# CITY OF ALBUQUERQUE

**Re: SF Towing Office**  
**Project Address**  
**Traffic Circulation Layout**  
Engineer's/Architect's Stamp **06-21-18** (D16 - D002A7)

Based upon the information provided in your submittal received 08-27-18, the above referenced plan cannot be approved for Building Permit until the following comments are addressed:

TRASH ENCLOSURE

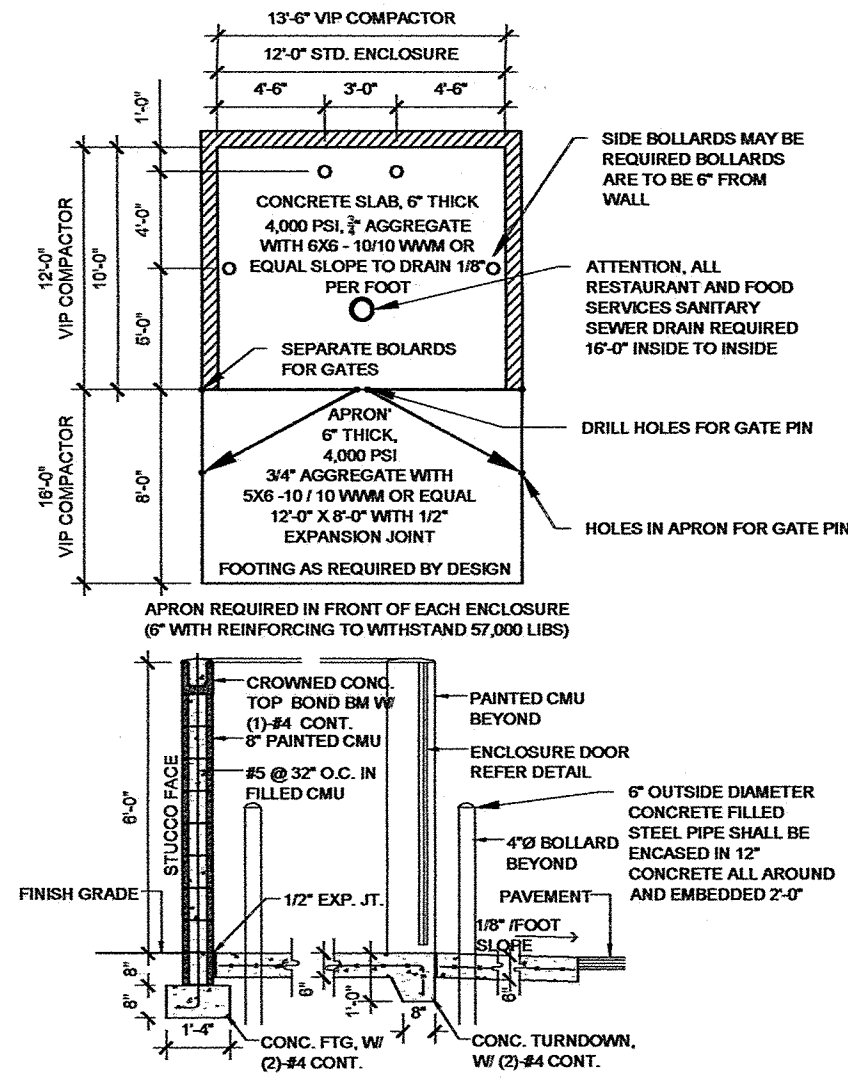
1. Address and legal description. The address seems to be incorrect. Please provide the correct address.
2. Service vehicle and/or refuse vehicle maneuvering must be contained on-site; provide a copy of refuse approval.
3. A 5 ft. keyway is required for dead-end parking aisles.
4. Please specify the location of the refuse/trash container.
